From: Yapton Parish Council Clerk [REDACTED]
Sent: 01 December 2021 11:56
To: Simon Davis <Simon.Davis@arun.gov.uk>
Subject: RE: Drove Lane Sales Cabin refs Y/141/21/PL and Y/142/21/A

The Parish Council now wishes to withdraw the Parish Council's objection to application Y/141/21/PL (*Temporary Sales Cabin & associated landscaping.....*).

With respect to application Y/142/21/A (*Various advertisements in various locations, Land East of Drove Lane, Yapton*) , the Parish Council objects on the grounds that:

DWH SUPPORT RED
C31 M87 Y66 K25

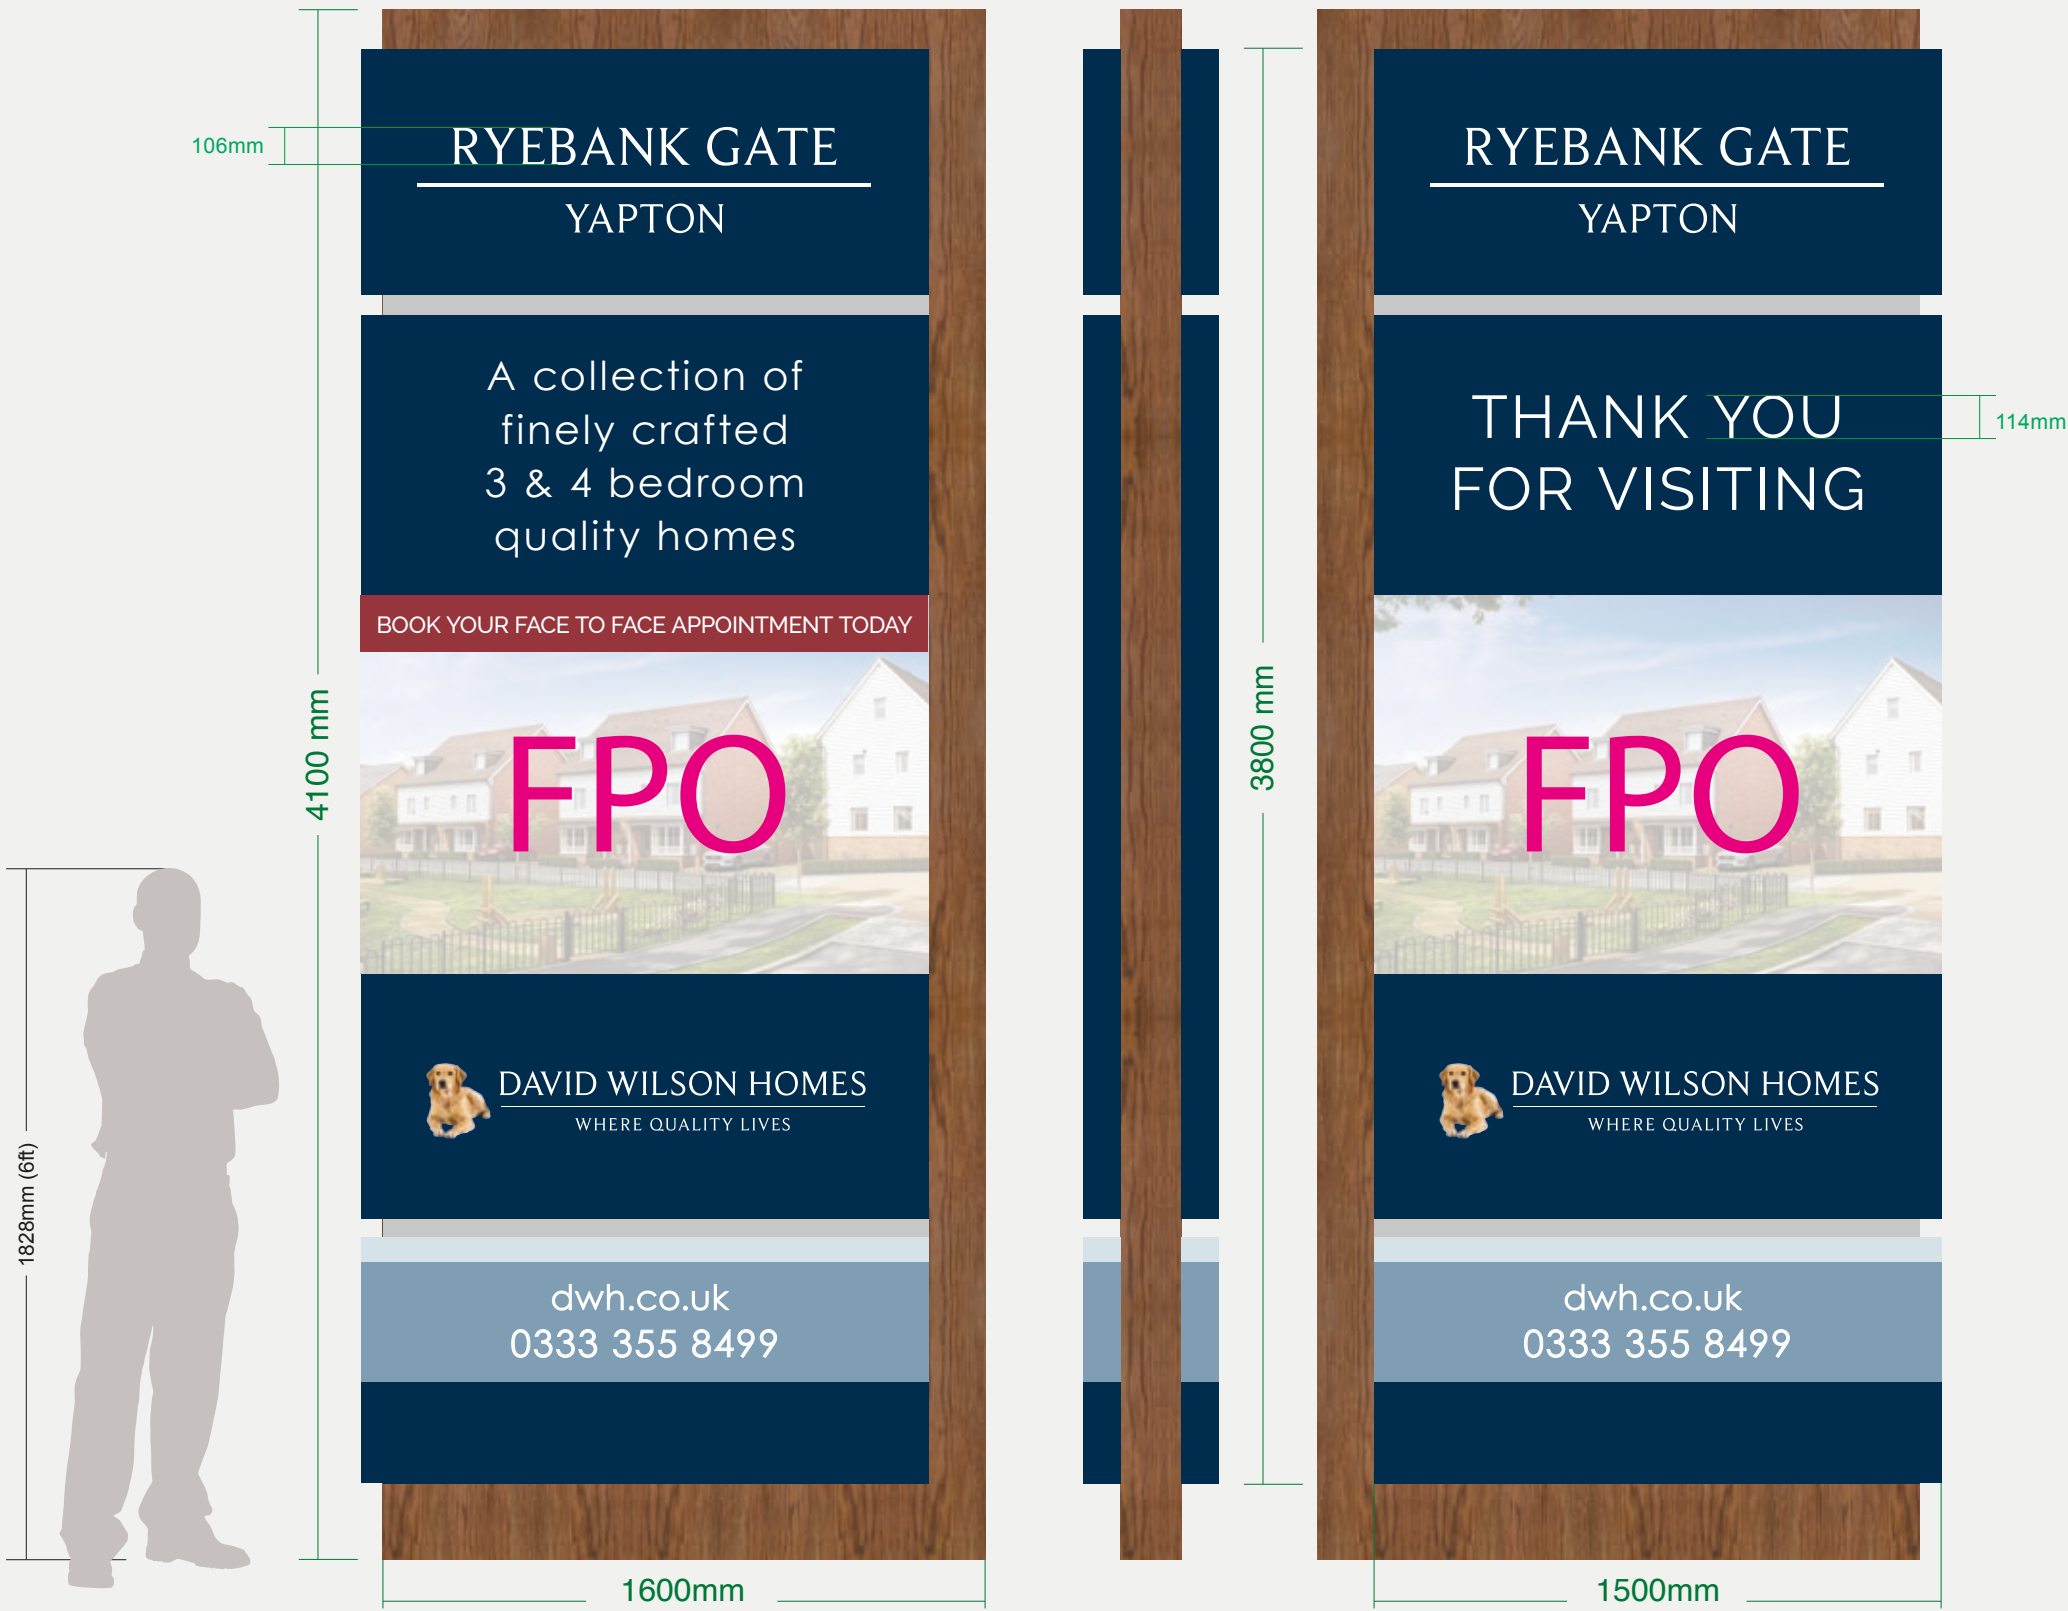
The concern is the level of signage fronting Main Road. By adding a further two 12 foot totems isn't going to remove or indeed lessen the clutter on the frontage. The Parish would strongly suggest the applicant simply has one totem and no more fronting the main road as per other house builders in Yapton. The Parish Council would request that the height restriction for the totem is no higher than 1.5m.
